**National Highways Planning Response (NHPR 21-09)
Formal Recommendation to an Application for Planning Permission**

Council's Reference: 22/0036

Location: AND BETWEEN GREENWAYS NUSERY AND 89 MAINS LANE, SINGLETON, FY6 7LD

Proposal: OUTLINE APPLICATION WITH ALL MATTERS RESERVED FOR THE ERECTION OF ONE DWELLING - RESUBMISSION OF APPLICATION 20/0735

DRAWING TITLE
Site/ Location Plan as PROPOSED

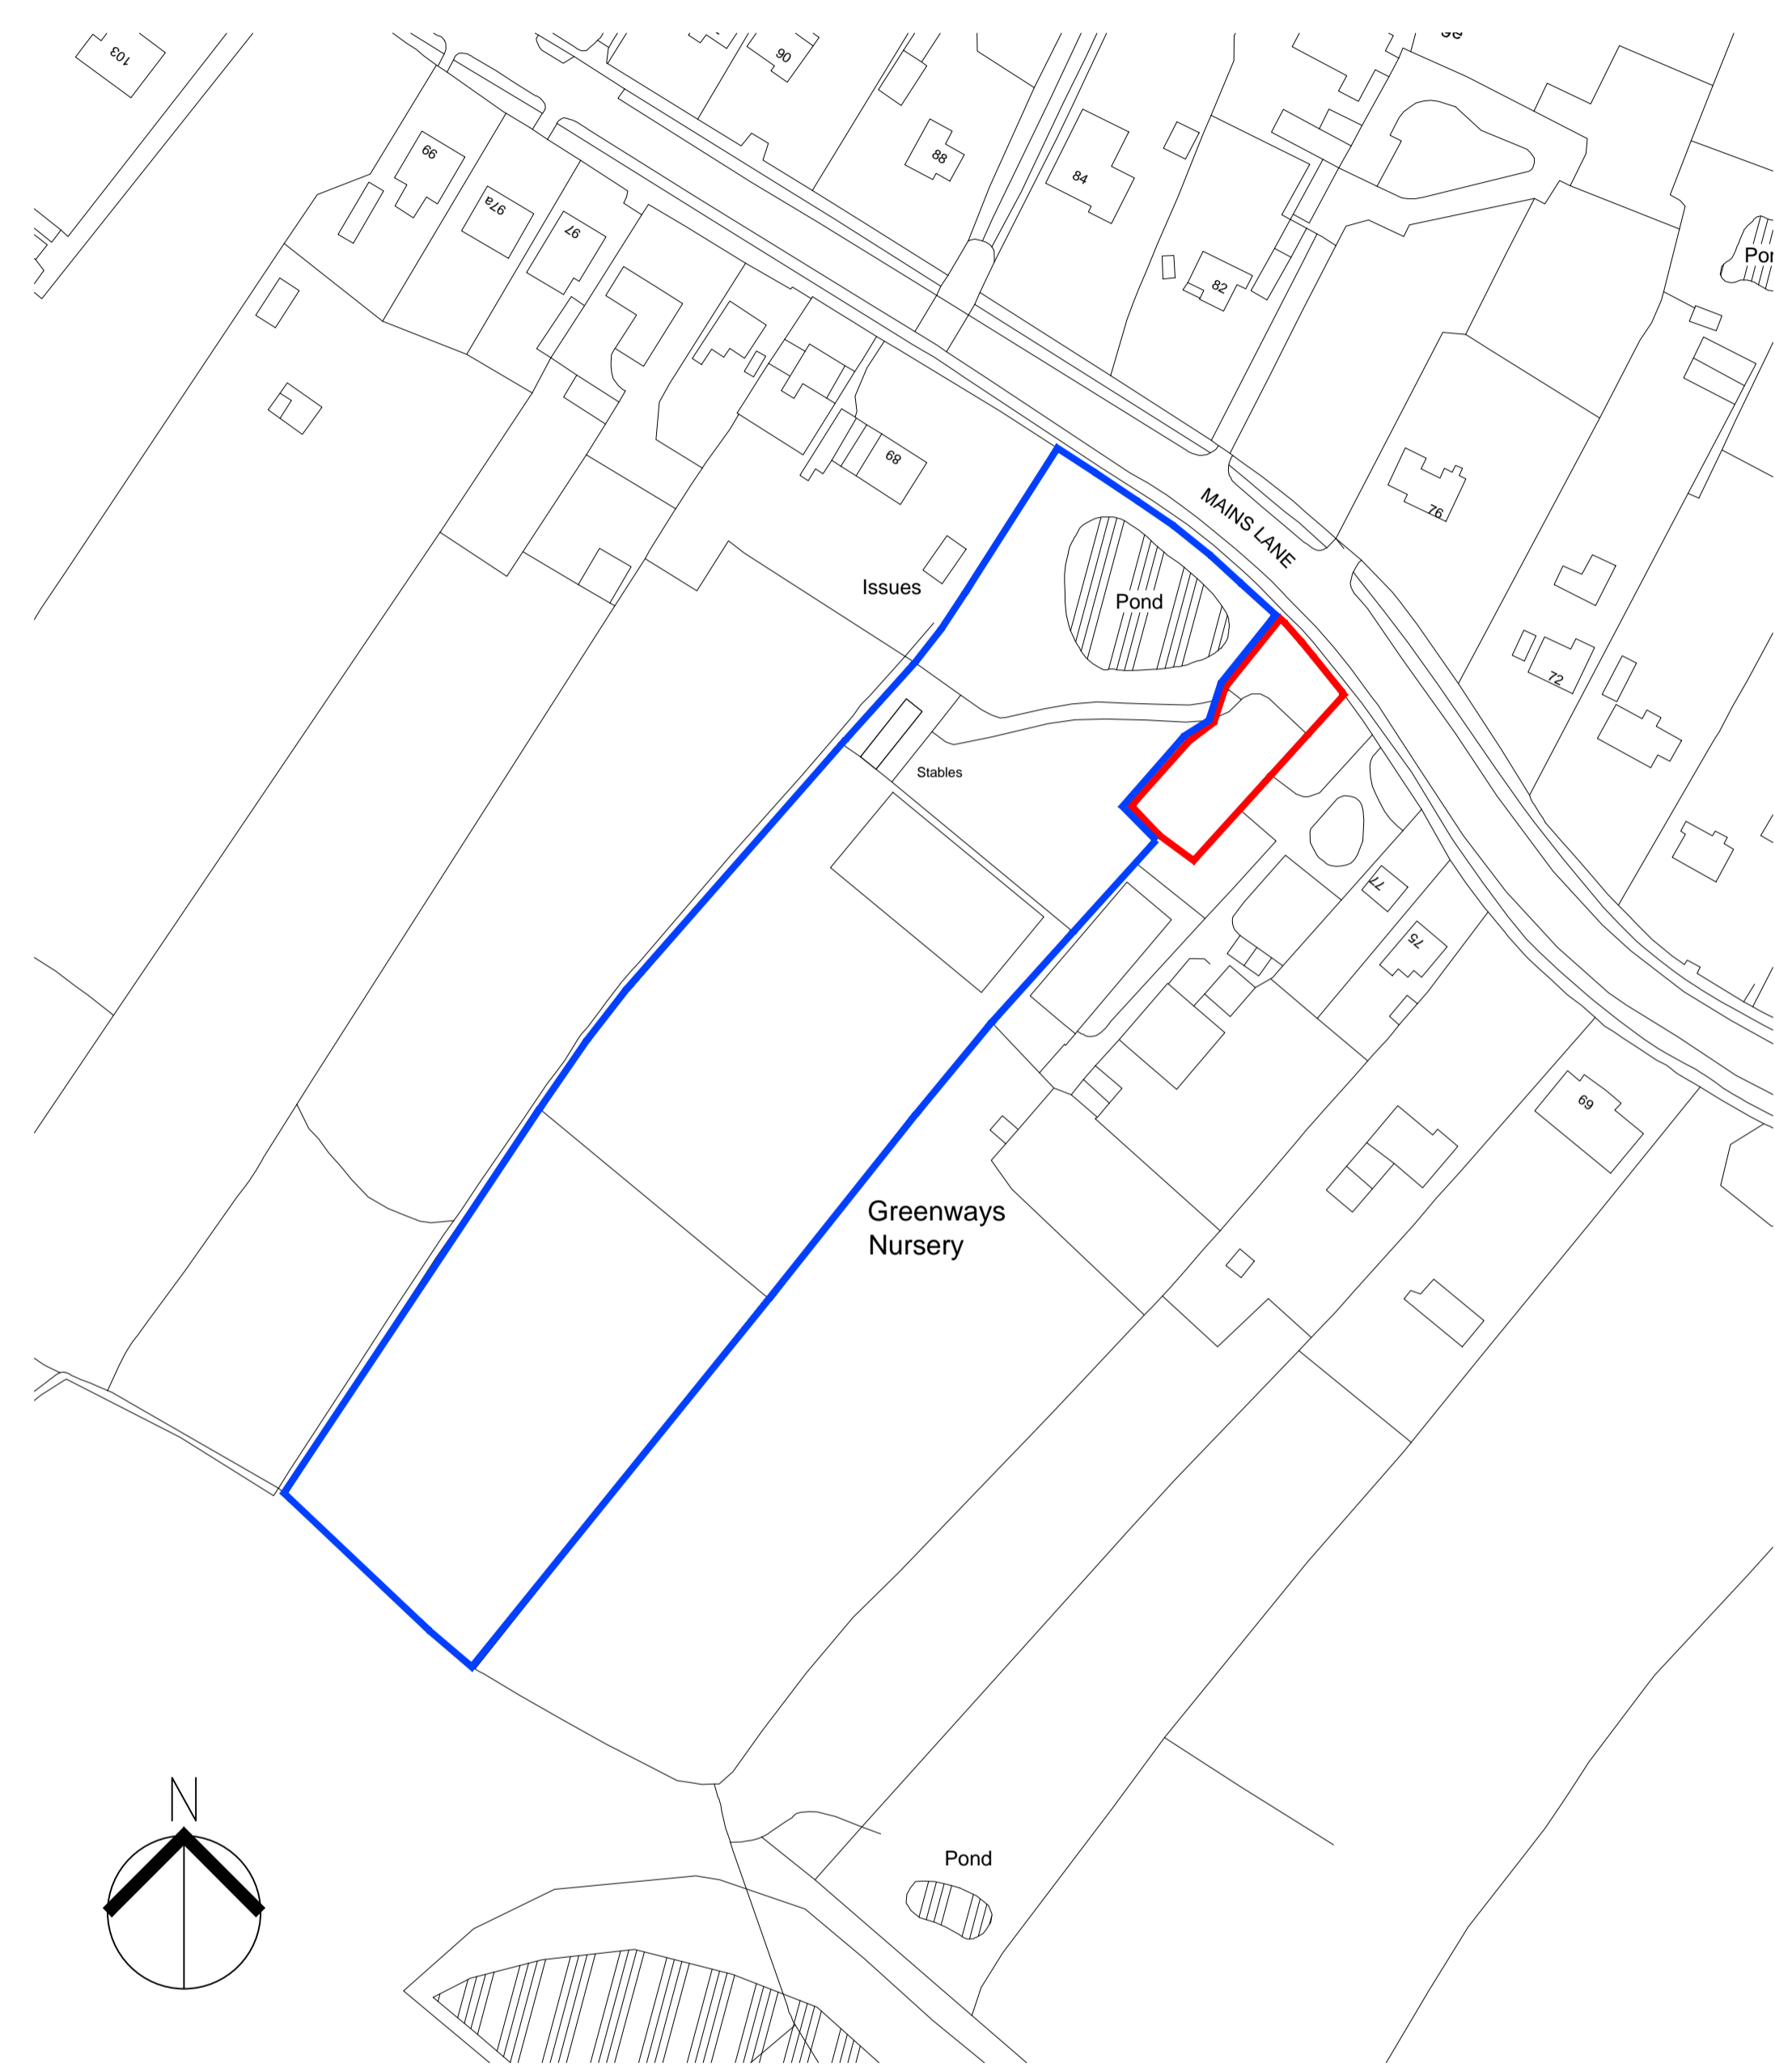
The site in question forms part of a wider open field containing an existing stable block, which is set back some distance from the A585 and is accessed via an existing field access onto Mains Lane. We note that the proposed dwelling would share this same access, which is only capable of allowing one vehicle in / one vehicle out at any one time – we therefore welcome the fact that the driveway layout of the proposed dwelling enables vehicles to turn within the site and therefore exit onto Mains Lane in a forward gear.

National Highways has no objection to the proposals on the grounds of the traffic generated, which would be minimal. In terms of safety, in our view, the standard visibility requirements for vehicles leaving the site of approaching traffic on Mains Lane of 120 metres in either direction are met, but that these are the very maximum distances that may be seen by a driver wishing to exit the site. Consequently, we suggest that the applicant might want to consider whether they could further improve visibility (particularly to the west) by amending their existing hedge line or, at the least, keeping it trimmed.

National Highways has no objection to these proposals, but formally recommends that the following conditions are attached to any grant of planning consent in the interests of maintaining the safety and integrity of the A585 trunk road:

1. There shall be no connection to the highway drainage system of the A585(T).
